Application number: 2022/92570	
What is the application for?:	Variation of condition 1 (Plans) on previous permission 2019/90727 reserved Matt
Address of the site or building:	106, Greenfield Road, Holmfirth, HD9 2LP
Postcode:	S35 7FG

title Plot 03 - GA Drawing
number 18131D-103-P07
scale 1:100 or as shown
size A1

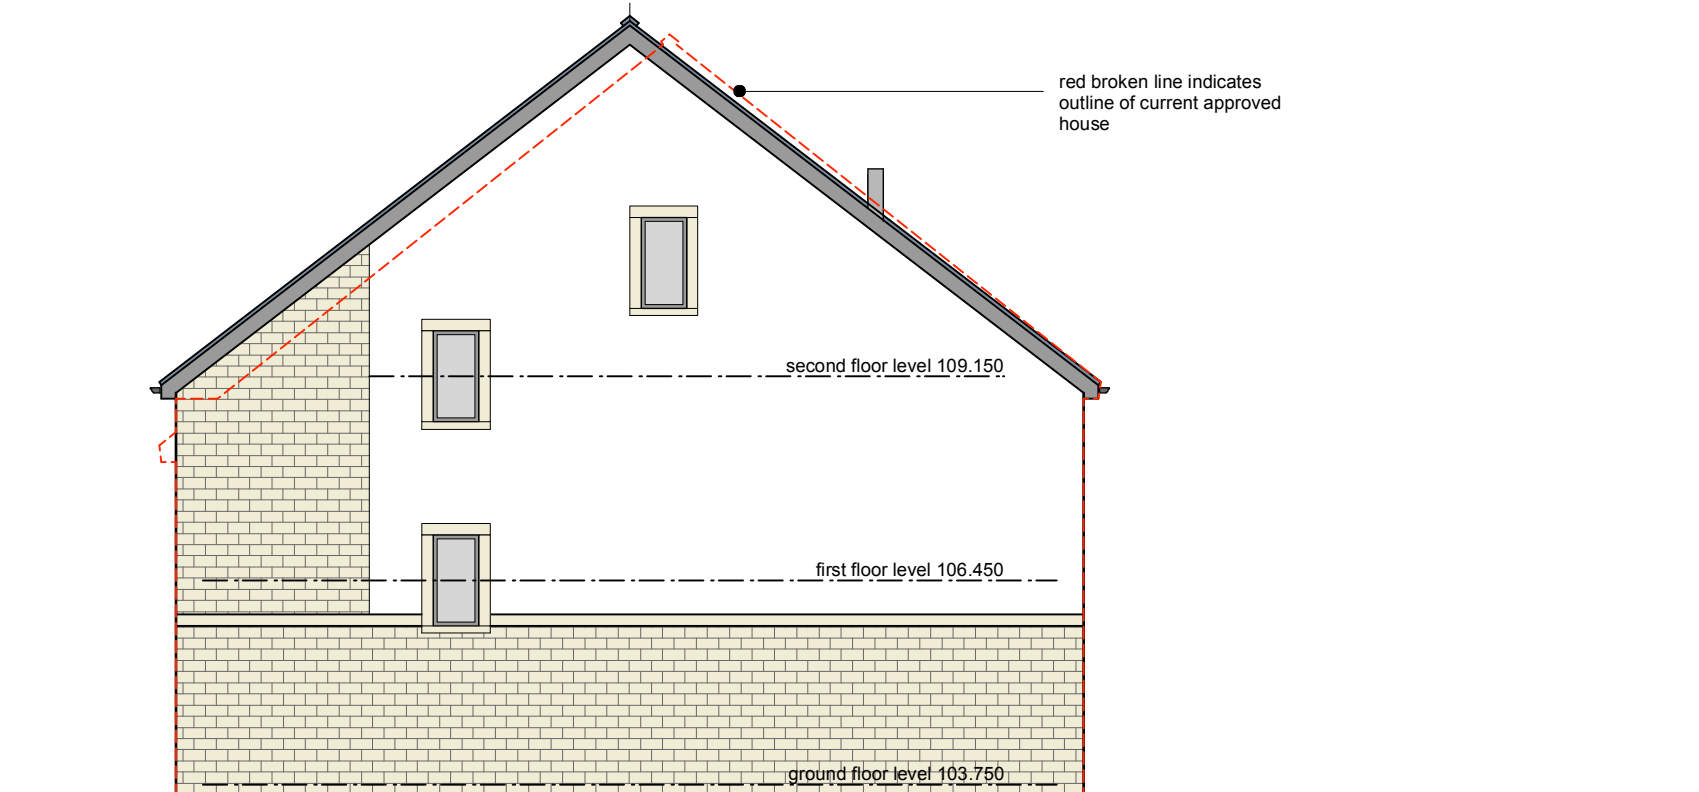
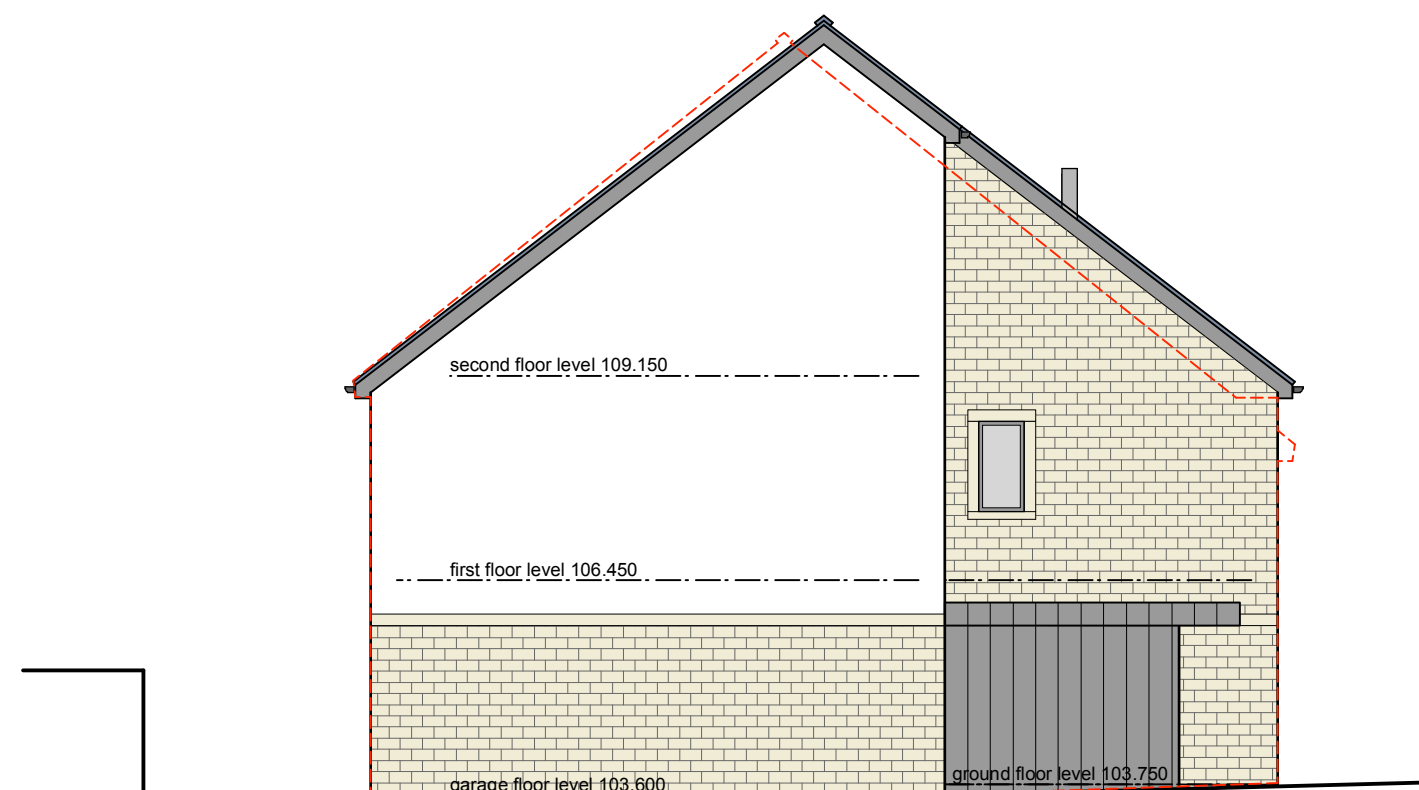
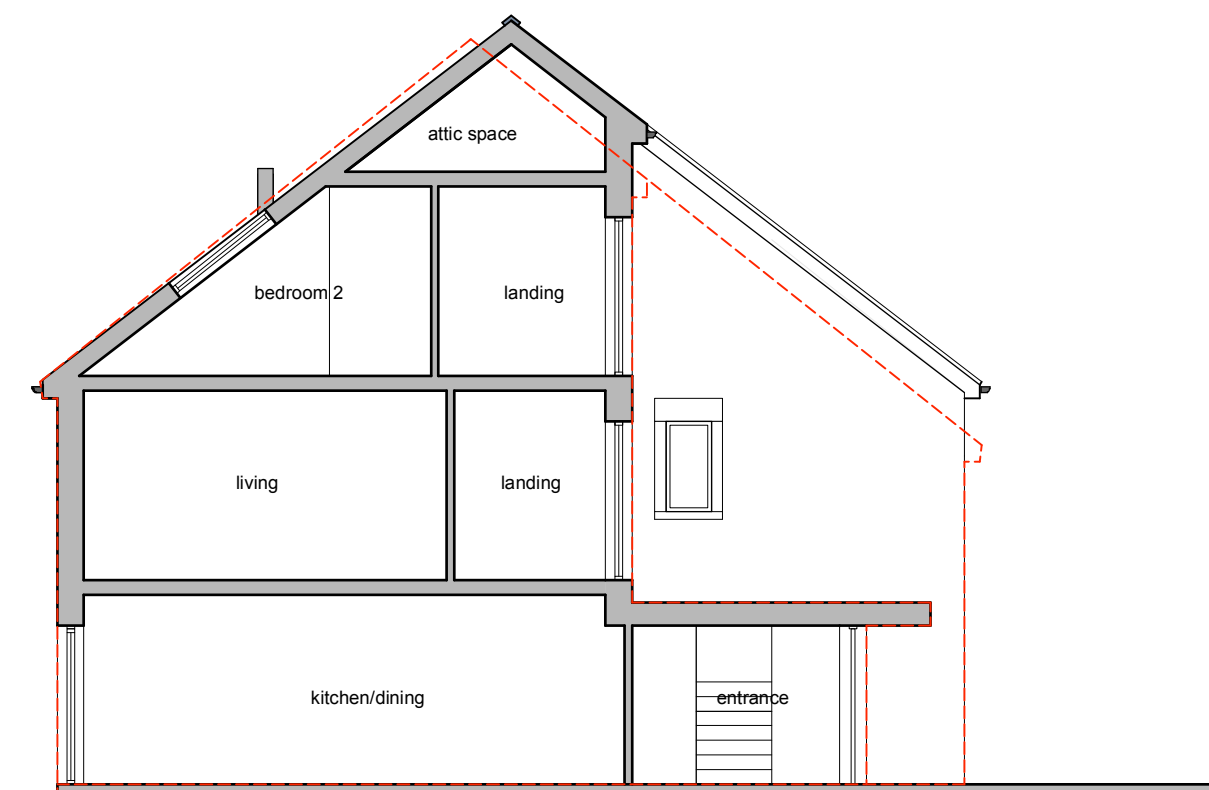
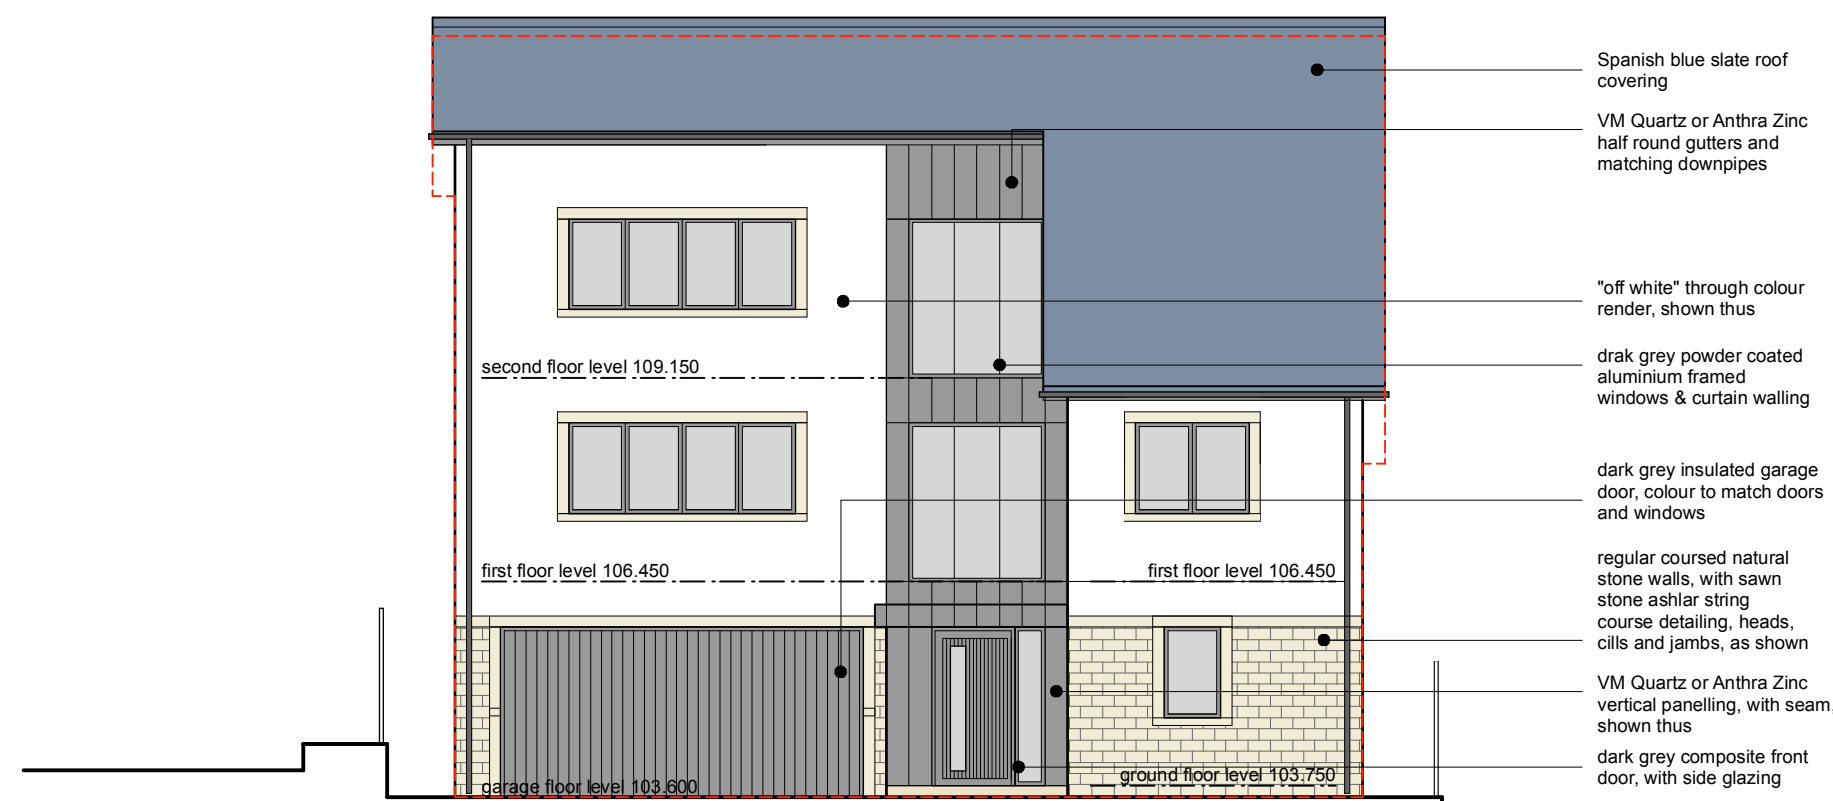
which are proposed behind our house (App ref 2015/94106; 2020/93548). we now seek updated reassurance and protection that the site will be closely monitored so that no more creeping changes will be implemented by the developer – specifically in relation to height and mass - which may adversely affect us but be found acceptable to the planning department.

We are asking that you check that the building is in accordance with the approved levels and heights - there has been no excavation or levelling of the access road from Greenfield Road - and that subsequent properties are constructed at the appropriate lower levels and are not built to excessive height.
